Necton
Norfolk

20th October 2021

Norfolk Boreas: submission on behalf of the Norfolk Parish Movement for an OTN

Title:	Scenario 1 Viewpoint 3: Lodge Lane North
--------	--

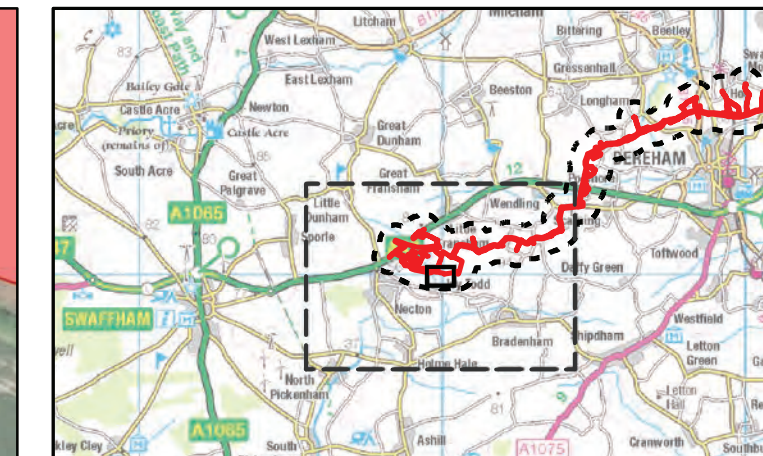
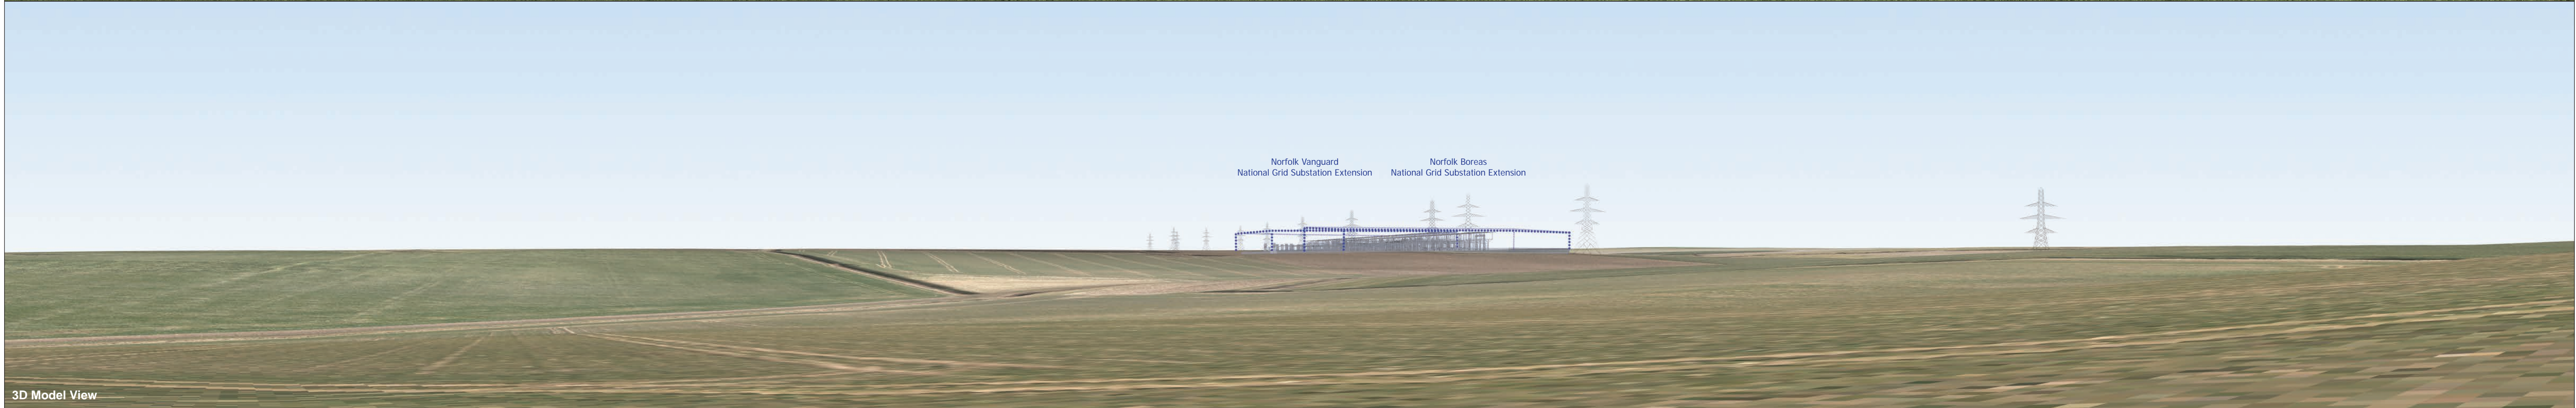
“The applicant has revised their Land form Cross-Section, Now in scale. I have added mitigating trees, and view line where appropriate. It again demonstrates the buildings are over 3/4 in view at viewpoint 3, and virtually 1/2 in view at viewpoint 7. This is still very different to the applicants visualisations, which show the buildings virtually totally concealed and totally concealed respectively.”

The applicant has ignored the concerns raised in REP8-35. Since no argument has been made by the Applicant to support the accuracy of the ground topography used in the light of the flaw pointed out in REP8-35, this calls into question the accuracy of the whole cumulative visual impact assessment provided to the examination. Therefore, the planning balance conclusion of environmental harm versus benefit is not safe.
